**Lawful Development Certificate for a Proposed Use or Development**

**Development:** Lawful development certificate for the proposed renewal of roof with Cambrian interlocking slate tiles.  
**Location:** 3 Orchard Close Ferring BN12 6QP

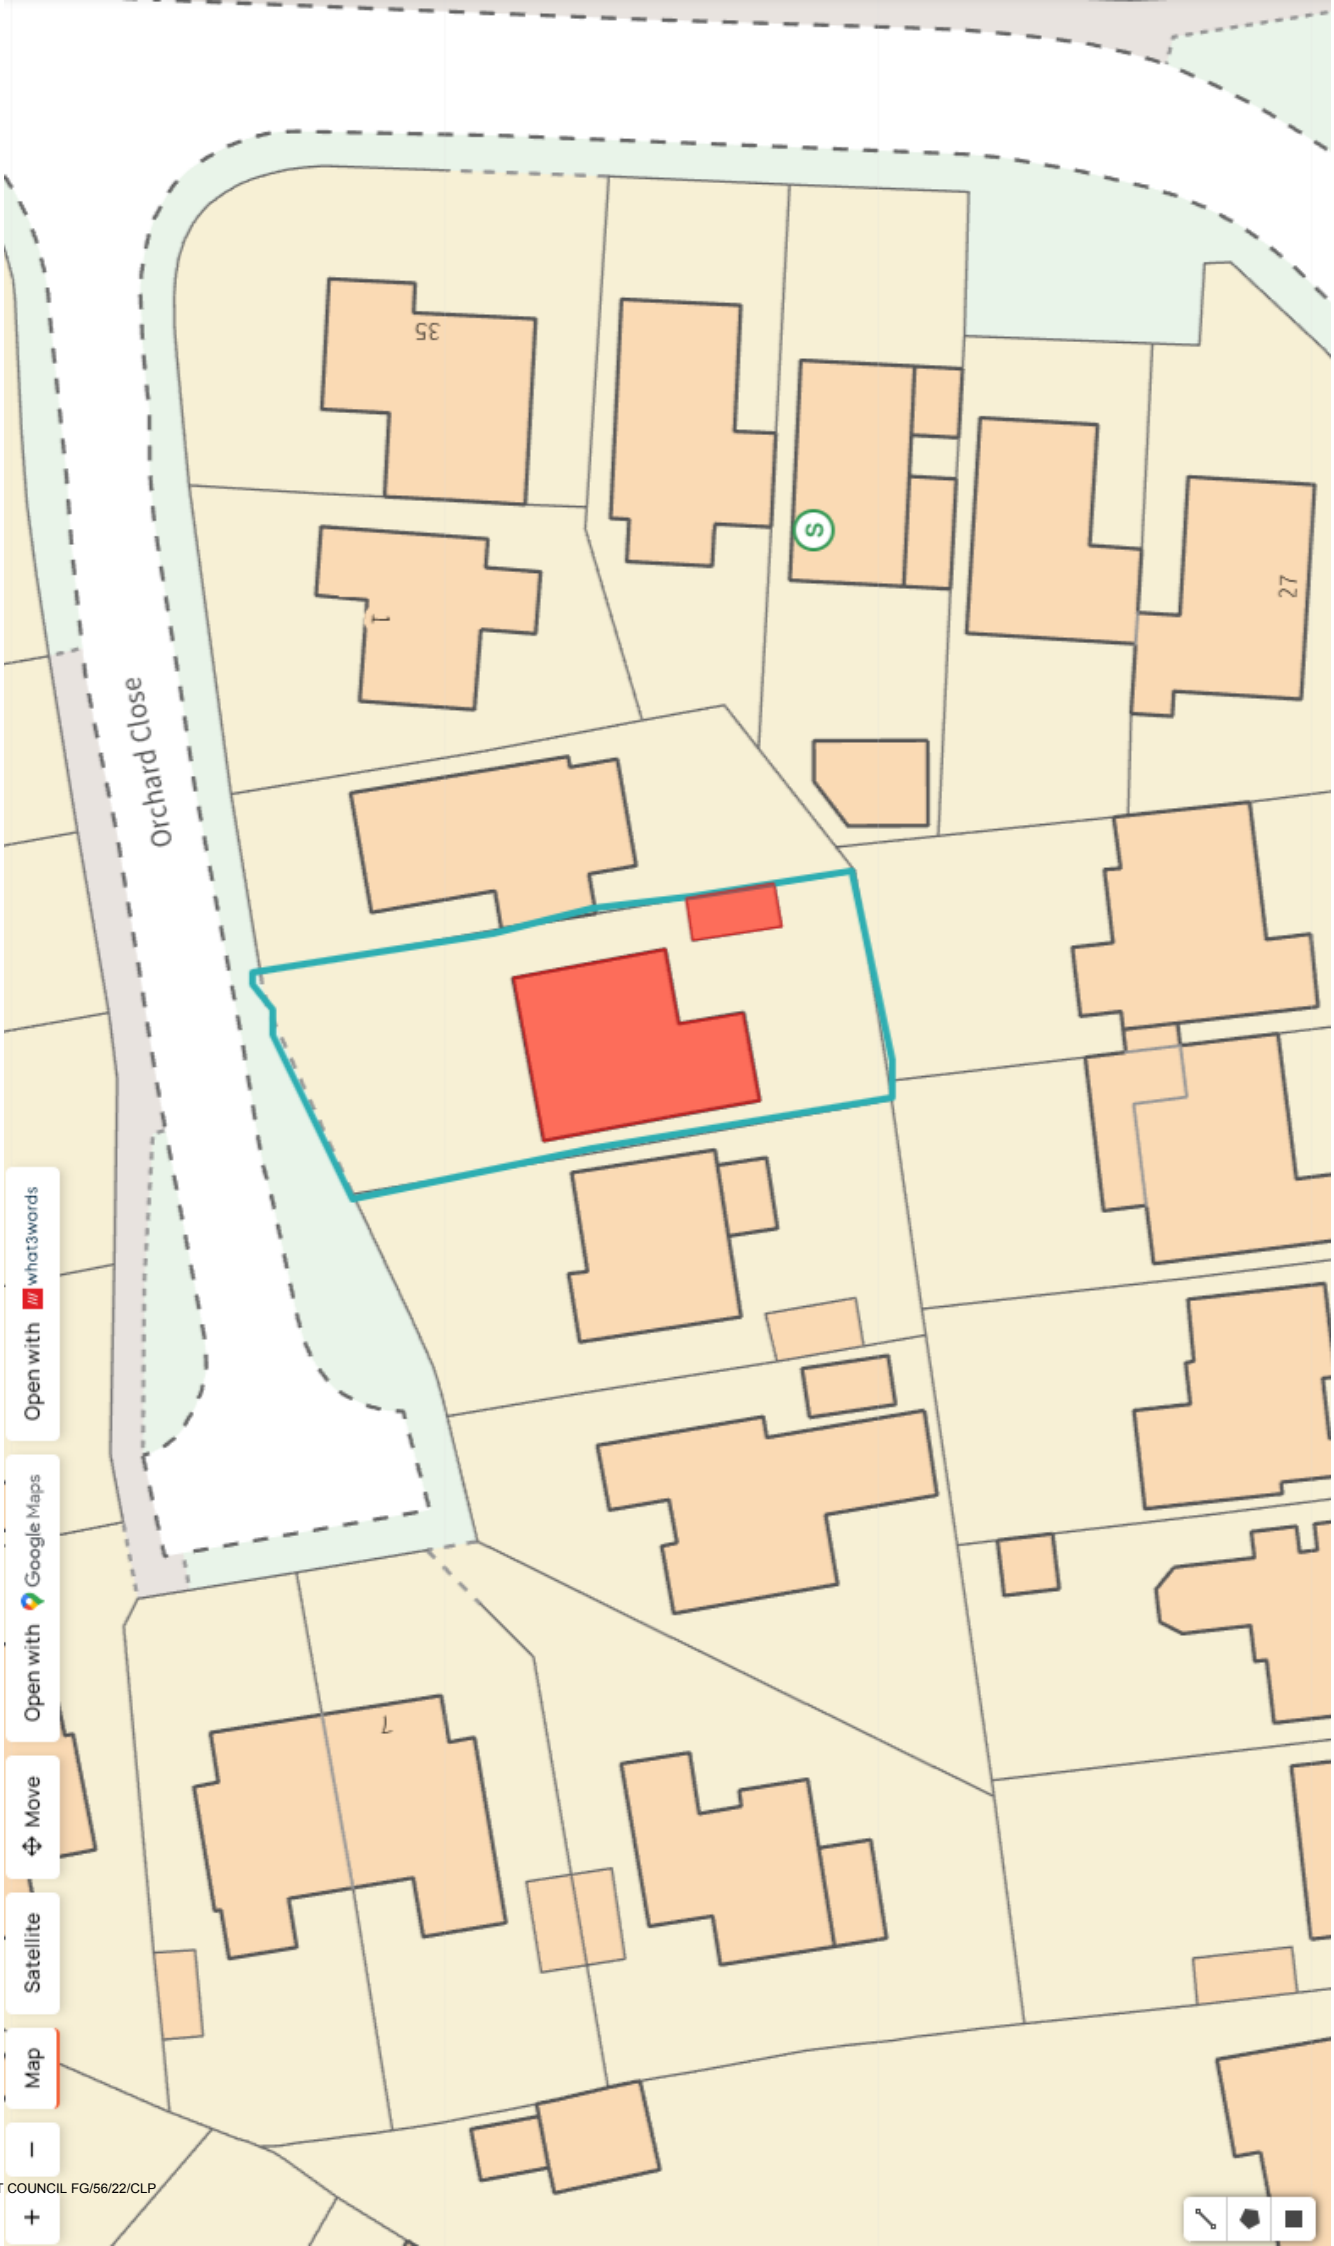
**Location Plan**

Please provide a scale and a north point on the location plan.
